February 22, 2016

RE: Nelson Agriculture Short Plat, SP-15-00010

The application for a Boundary Line Adjustment of Parcel Number 314334 for a 3 lot Agriculture Short Plat on approximately 59 acres of land that is zoned Agriculture 20, located in a portion of Section 17, T18N, R19E, WM, in Kittitas County, Assessor's map number 18-19-17000-0012 was received on December 31, 2015. Your application has been determined complete as of February 22, 2016.

KITITAS COUNTY	WASHINGTON
DWN BY <u>G. WEISER</u>	DATE <u>02/2016</u>
JOB NO. <u>15177</u>	
CHKD BY <u>S.W./M.K.K.</u>	SCALE <u>1"=200'</u>
SHEET <u>1</u>	OF <u>3</u>

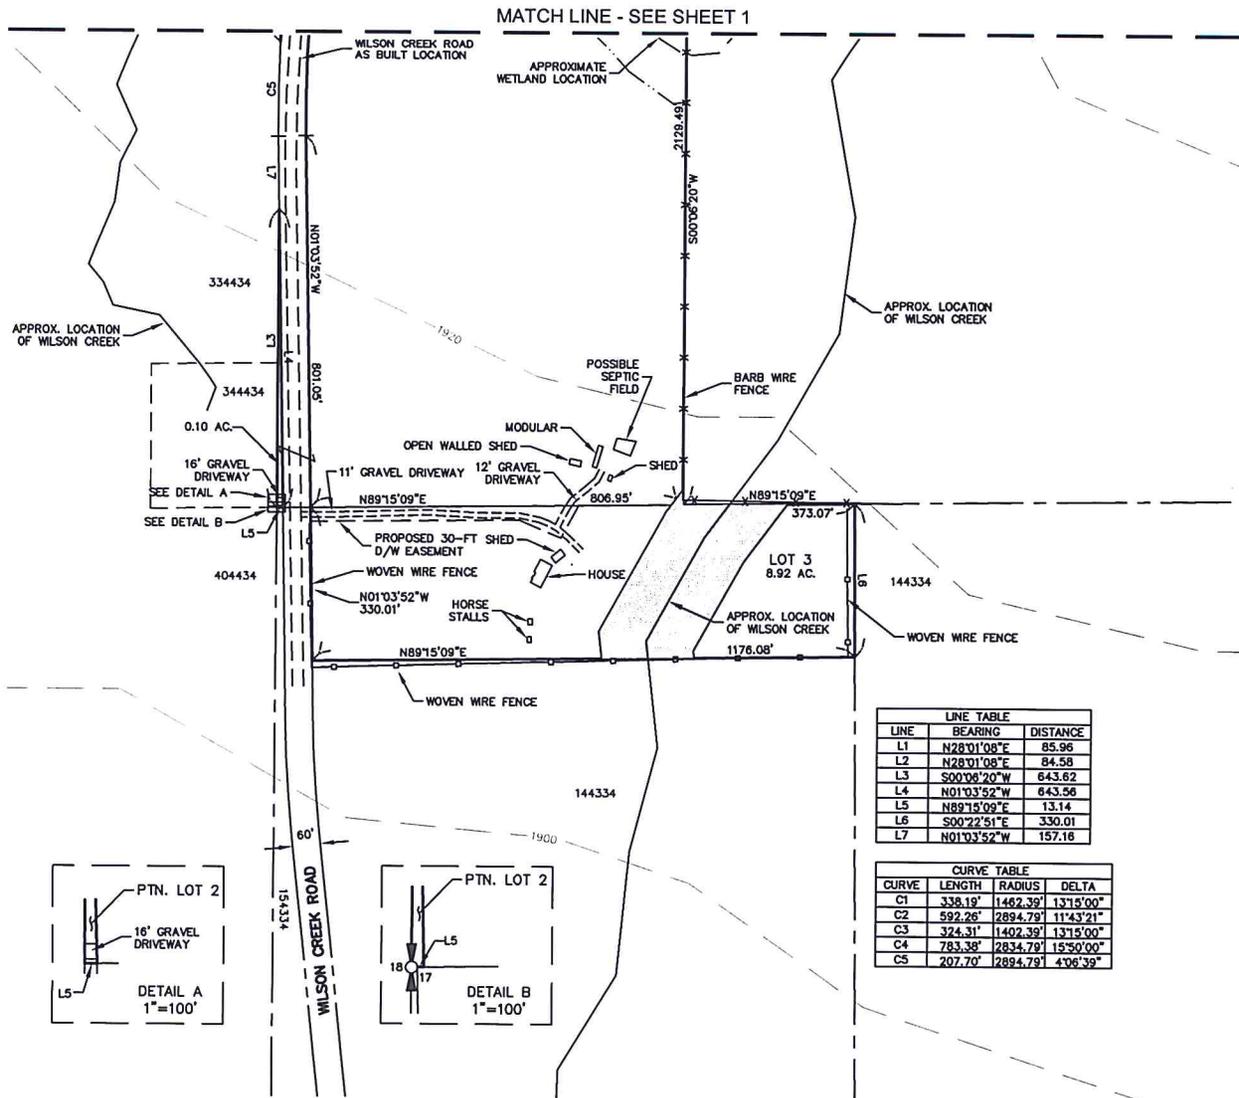
During review staff has determined that a revised site plan showing all septic's and drain fields is required in order to continue review. Additional information must be submitted to CDS within 180 days :
